Our Case Number: ABP-314724-22

Re: Railway (Metrolink - Estuary to Charlemont via Dublin Airport) Order [2022]
Metrolink. Estuary through Swords, Dublin Airport, Ballymun, Glasnevin and City Centre to
Charlemont, Co. Dublin

Re: Railway (Metrolink–Estuary to Charlemont via Dublin Airport) Order 2022
Case Reference Number NA29N.314724

Client	TII NTA	Project	METROLINK	Drawing Title	METROLINK - STRUCTURES CHARLEMONT STATION PROPOSED STREET LEVEL DESIGN	Drawing Status	S0
Consultant	JACOBS IDOM	Drawing N°	ML1-JAI-SRD-ROUT_XX-DR-Z-02090	Plan Drawing N°	ML-ST 307 O-A1		
		Scales Original Size A1	1:250			Sheet	1 of 6

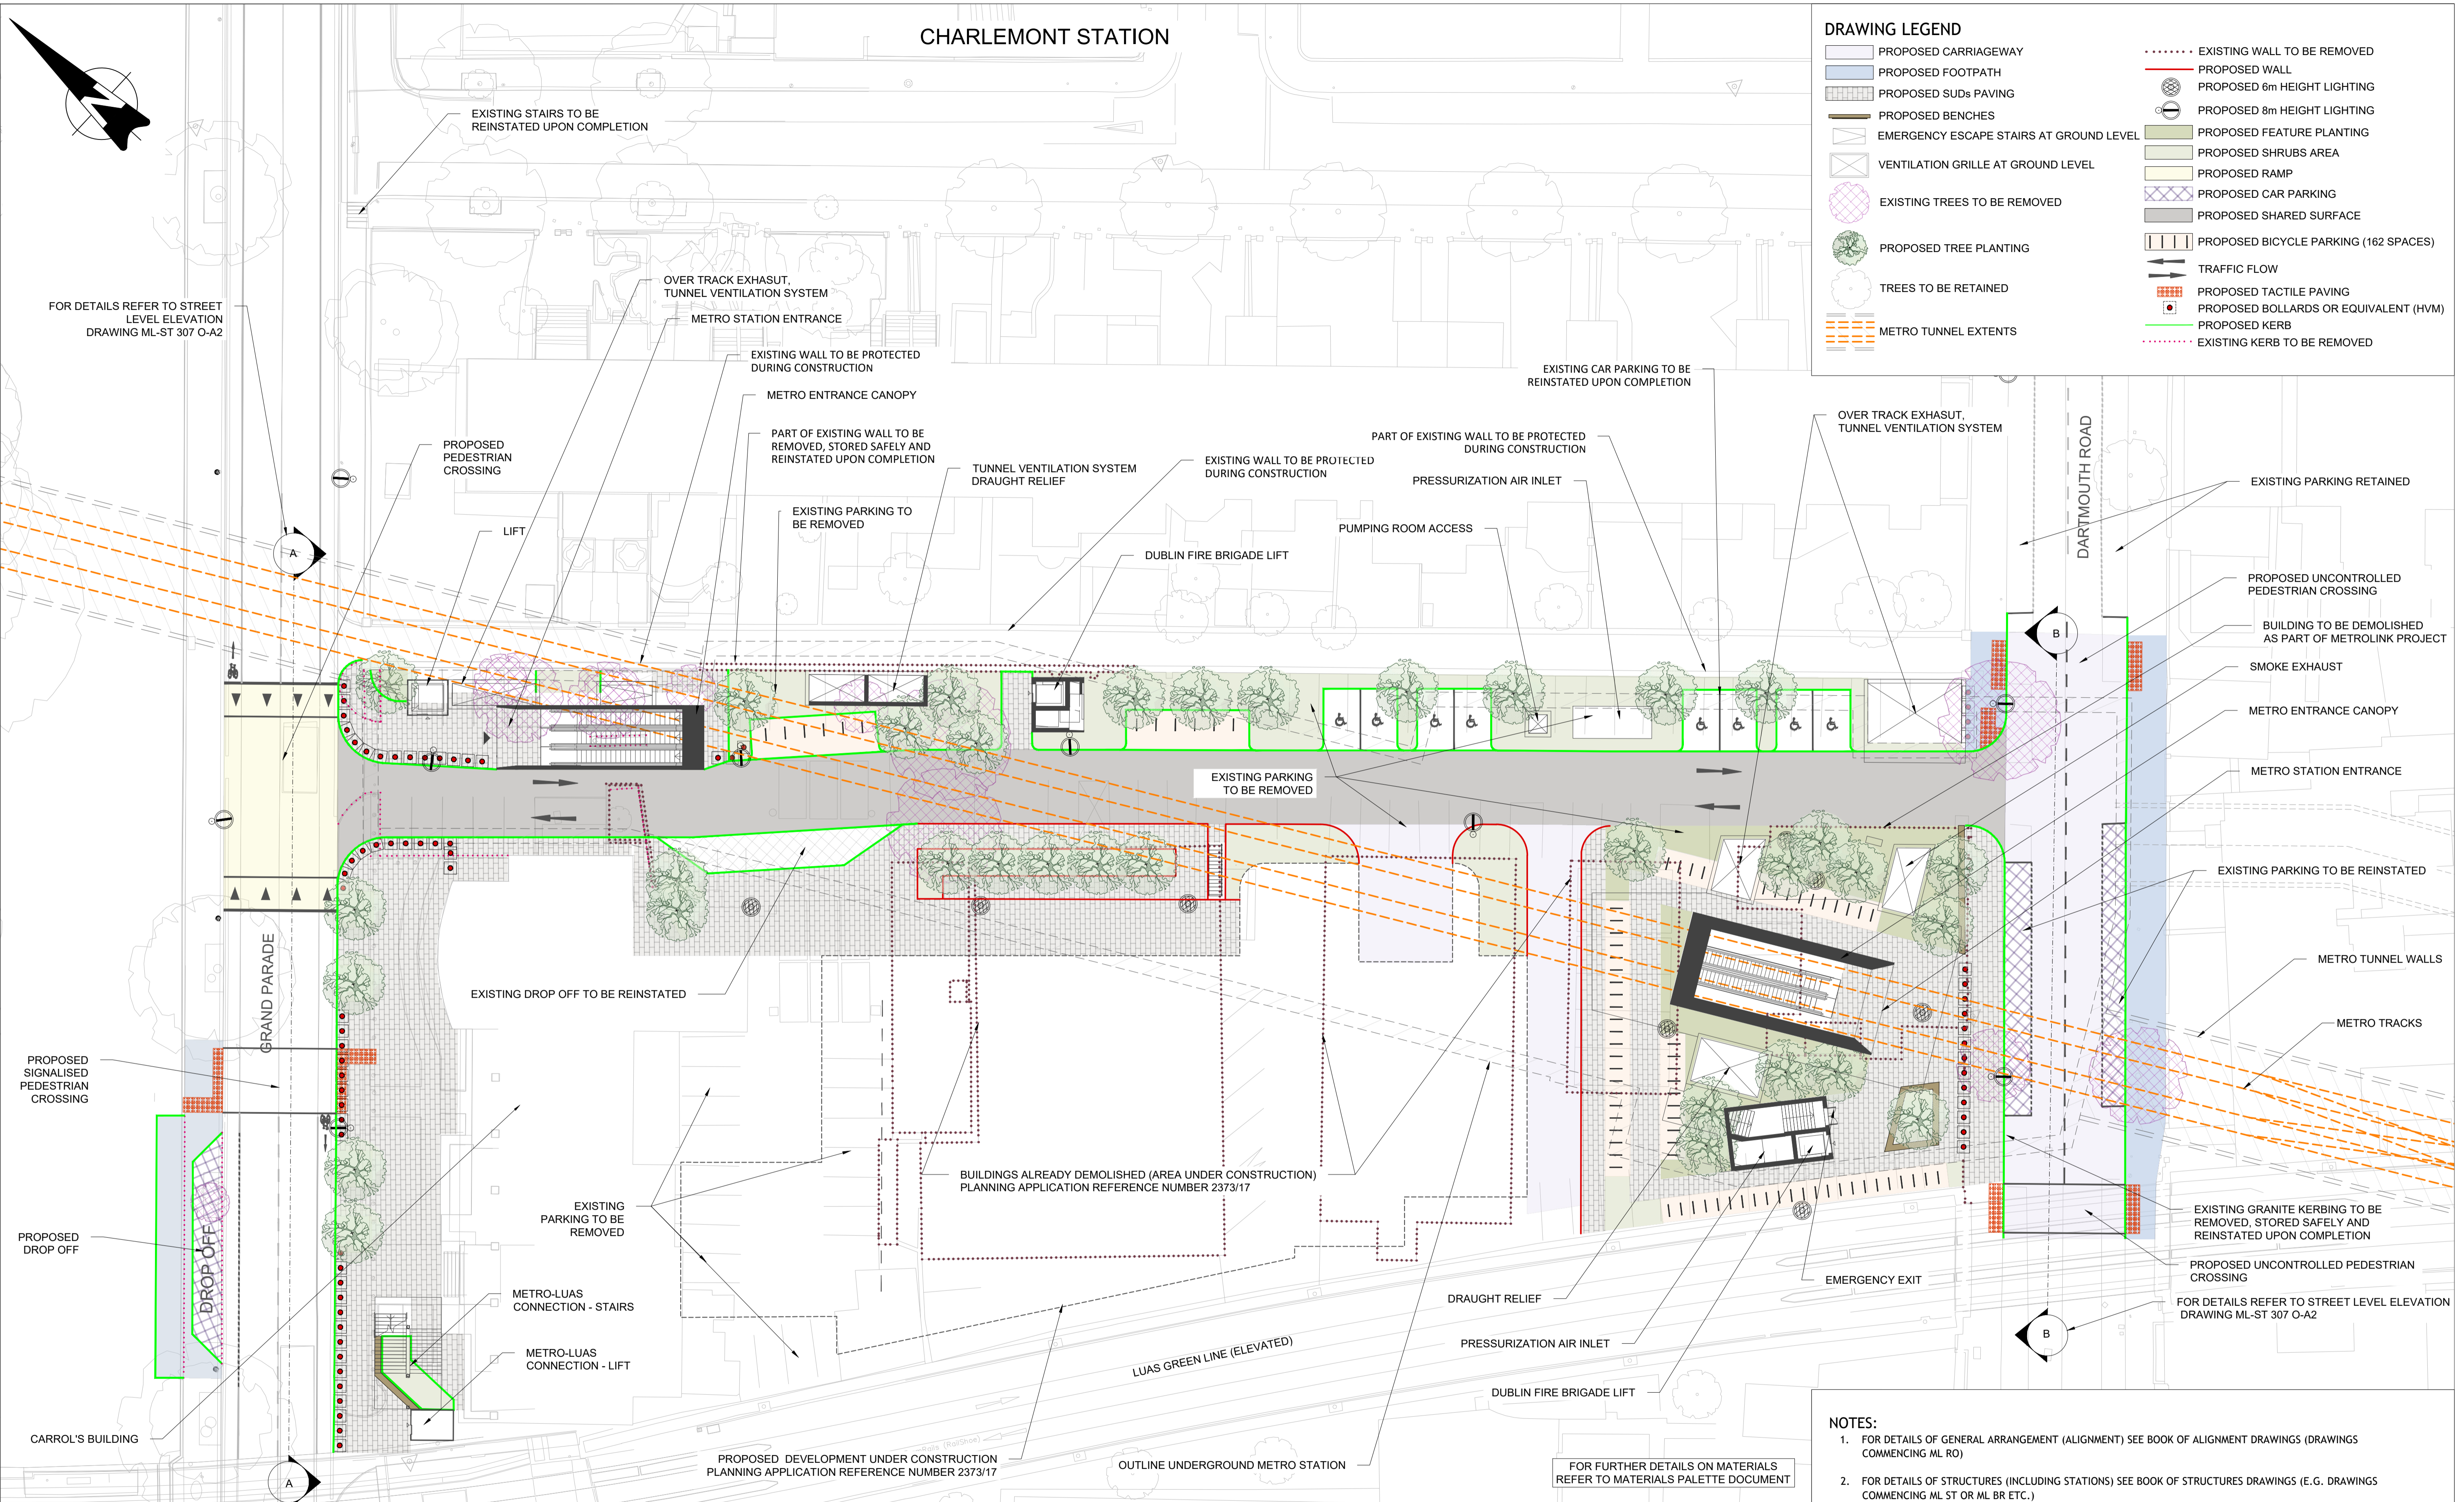
5. At the OH, our Structural Engineering expert, Mr Brian Kavanagh, stated that the level of ground settlement which TII had indicated would occur (up to 30mm) would severely damage the structural integrity of the Victorian 3-storey brickwork houses. It was also pointed out that settlement can be caused by the leakage of groundwater into the excavation, from the clay beneath the foundations; and to mitigate the risk of such settlement, the optimum method of preventing water ingress into the excavation should be used. We had understood from an earlier meeting with TII that their proposal involved the construction of a diaphragm wall (D-wall) prior to excavation. At the OH, it emerged that TII were keeping open the option of using a Secant Pile wall instead of using the more expensive D-wall, despite the admission by TII under questioning at the OH that the D-wall would be more effective.

6. At a meeting between residents of Dartmouth Square West and TII on 11 September 2024, TII presented a drawing showing a D-wall to the rear of some of the houses adjoining the excavation – but continuing on as a Secant Pile Wall behind other houses in the terrace. We expressed our concern, given the vulnerability of the Protected Structures, that they were not optimising their mitigation of the settlement risk; we requested that they consider changing the secant pile section by continuing the D-wall behind all of the houses on the terrace and around the entire excavation. They agreed to consider the request.

9. TII revealed at the OH a plan to build a 7-metre high noise barrier as an airborne noise mitigation measure along the eastern side of the site. This barrier will border on the Back Lane which runs behind the terrace of homes # 1 – 17 on the west side of the Square. From our experience of a noise barrier erected in the same location by Sisk during the Hines development, we believe that TII's proposed barrier will be ineffective. Our concern here is that the (unmitigated) EIAR predicted airborne noise values are well above the threshold level in all 6 phases of the 8 ½ year construction period. These are TII's own numbers – so a mitigation failure of the noise barrier will expose residents to many years of constant exposure to very uncomfortable levels of noise.

2. Condition the Railway Order to require that the D-wall method of construction must be used around the excavation of the station box;
3. Condition the Railway Order to require that TII indemnify the residents of Dartmouth Square West against all loss and damage with a guarantee to pay the full costs of whatever repair or rebuild might be necessary to restore our houses to their original condition; and
4. Condition the Railway Order to require that TII provide a triple-glazed solution for the rear windows of the houses in Dartmouth Square West.

Drawing Title	METROLINK - STRUCTURES CHARLEMONT STATION STREET LEVEL ELEVATION	Drawing Status	S0
Drawing N°	ML1-JAI-SRD-ROUT_XX-DR-Y-02091	Plan Drawing N°	ML-ST 307 O-A2
Scales	Original Size A1 AS SHOWN	Sheet	2 of 8

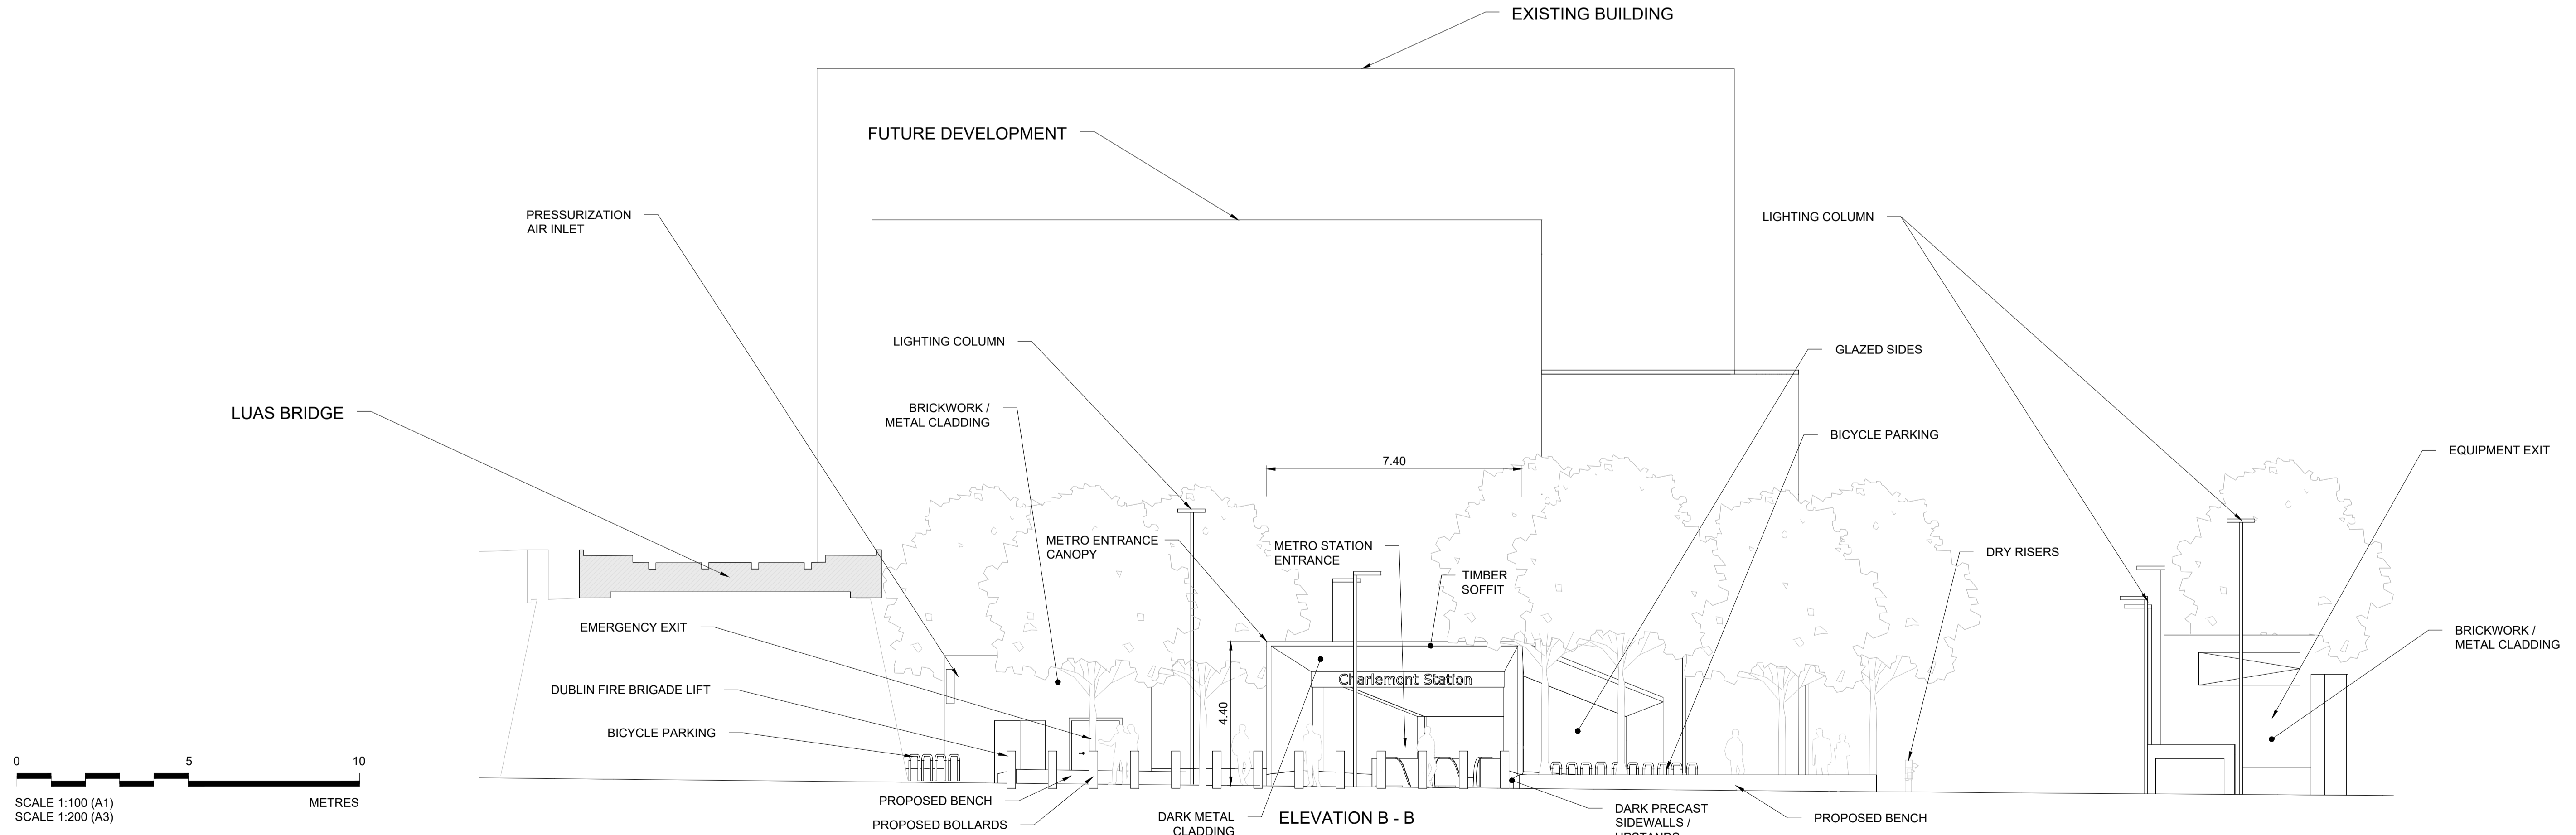
4. As a final insult to proper planning and development, the proposed open stairway from the Luas platform down to the footpath will permanently obscure, and diminish the value of, the existing fine front elevation of the Carrolls' Building, which is a Protected Structure.
